Food Growing

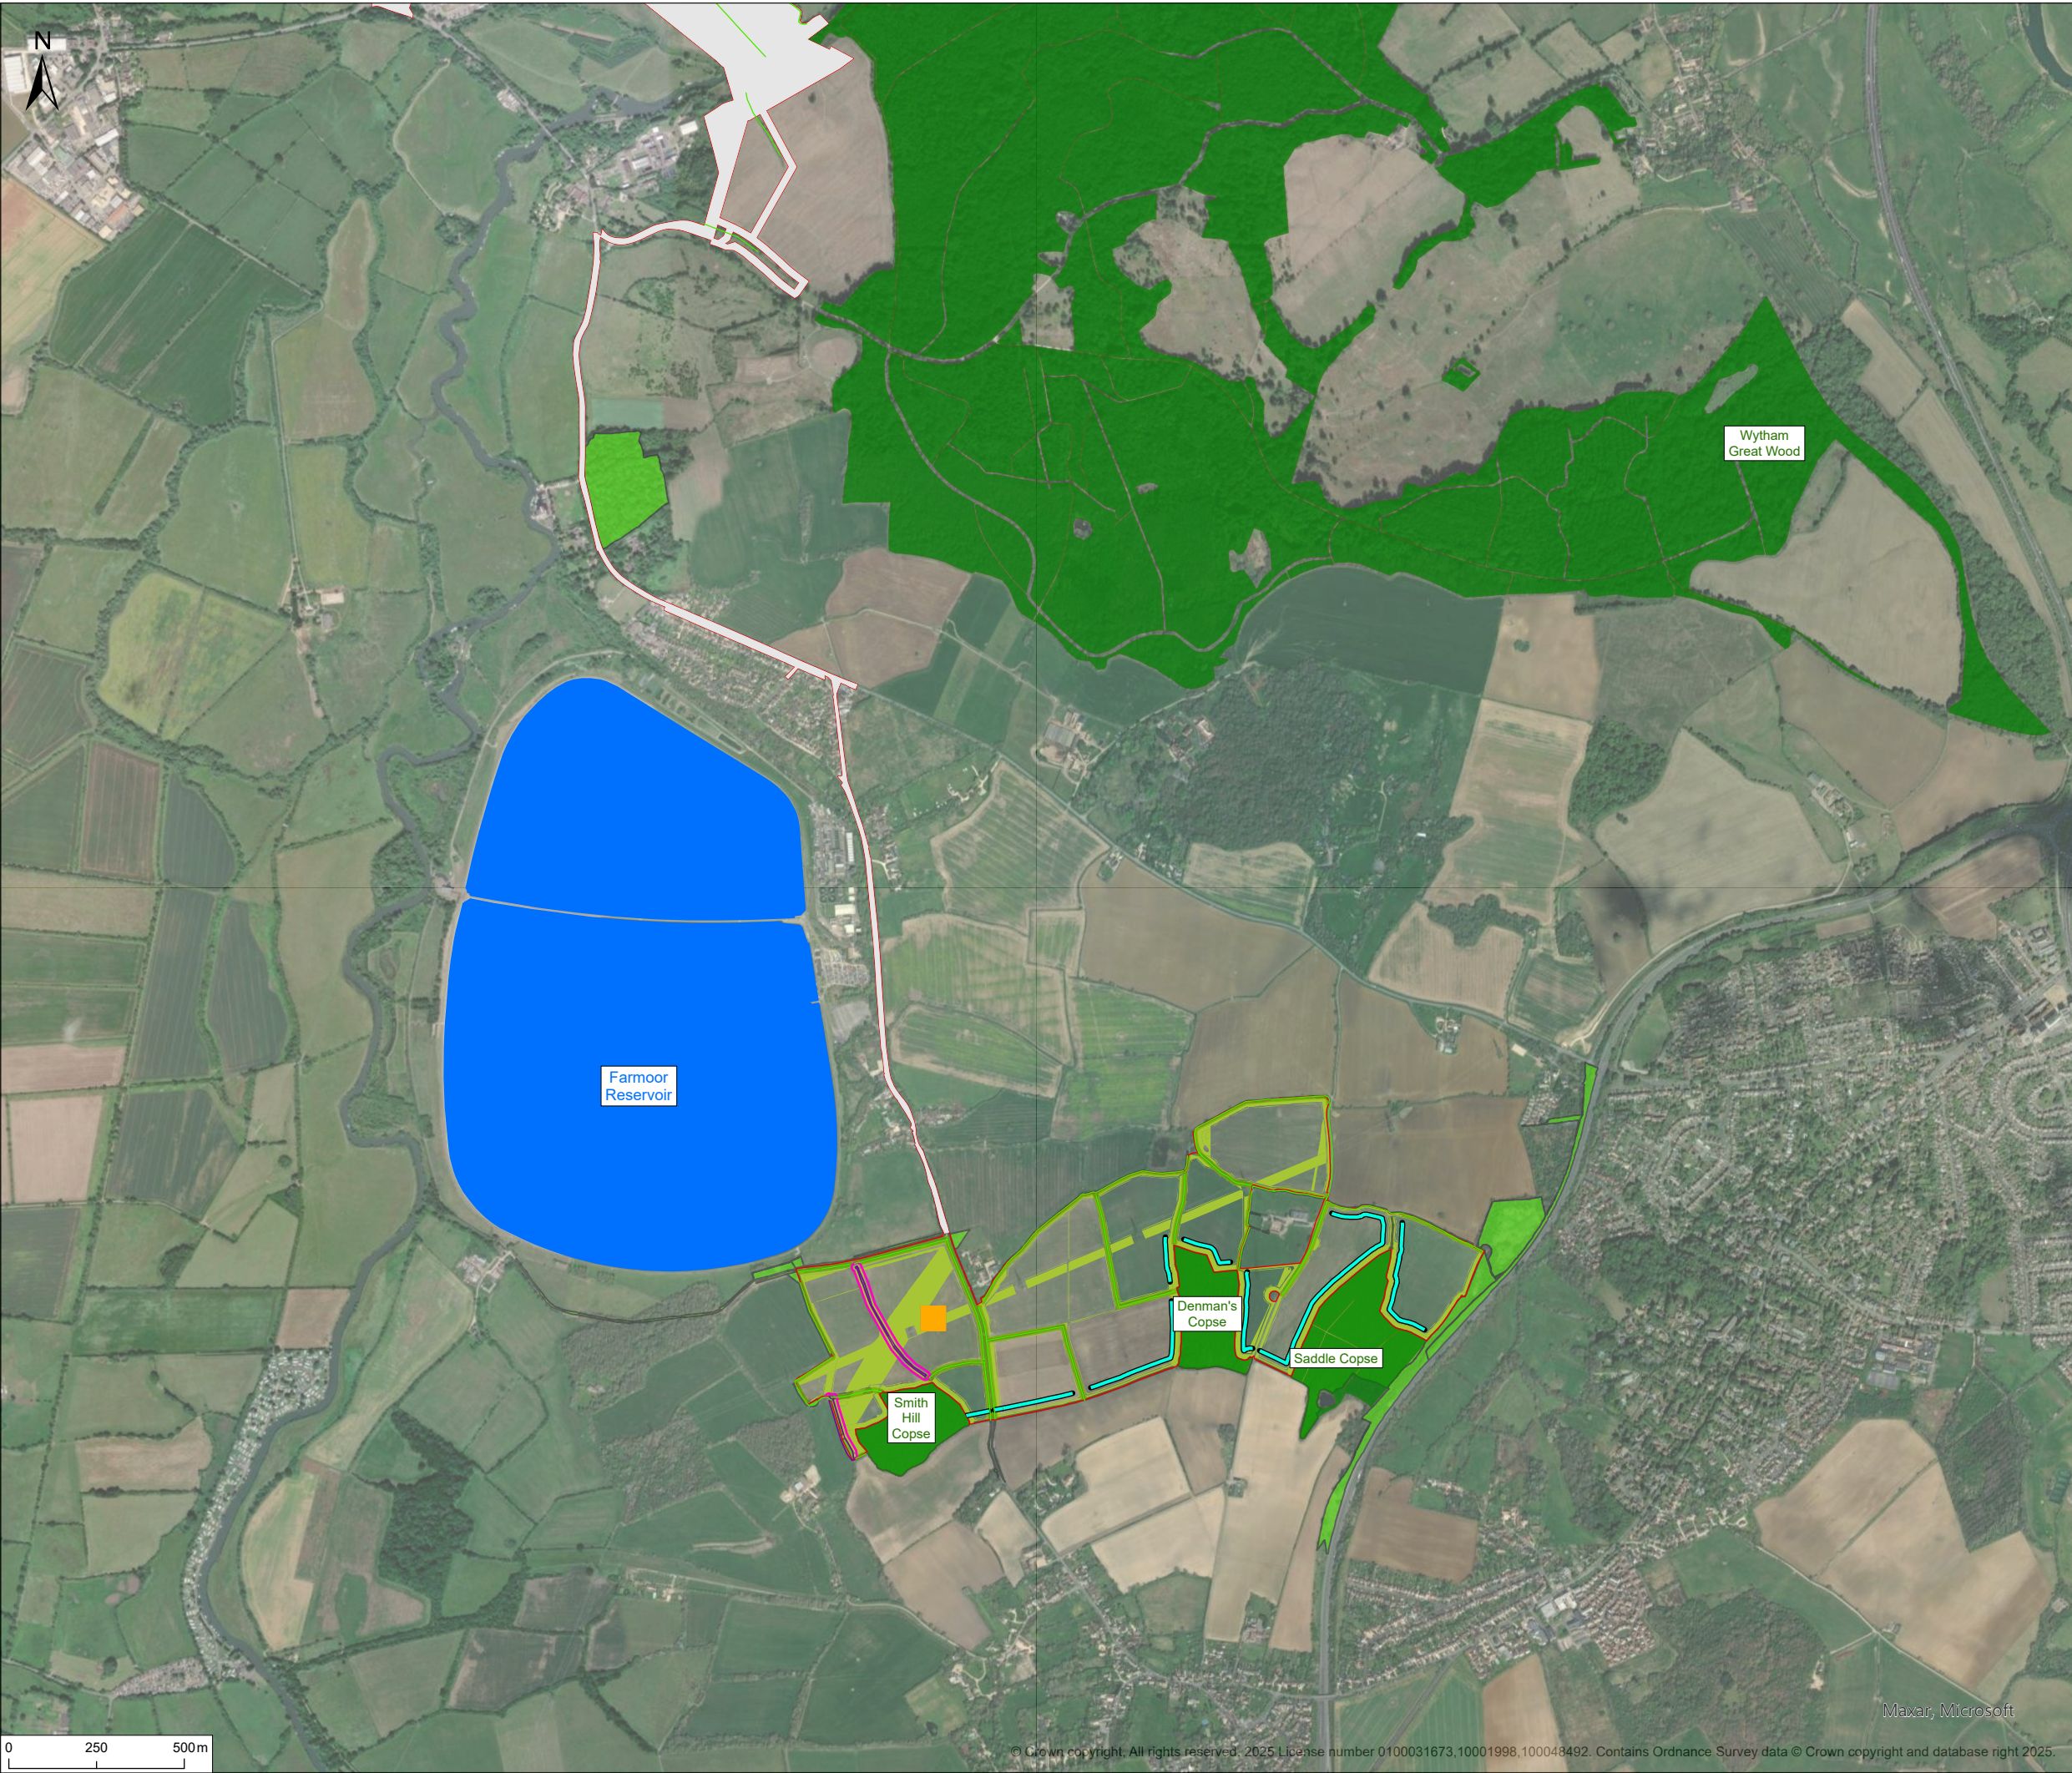
Land retention for Food growing in Bladon and the Hanboroughs - not as originally presented by the developer as the promised allotments for the local community to be placed on the outskirts of villages is now to be used by commercial enterprises selling food elsewhere so no community benefit. This was introduced without consultation with any Parish Councils or relevant village organisations. (ExQ2.5.4,2.5.5)
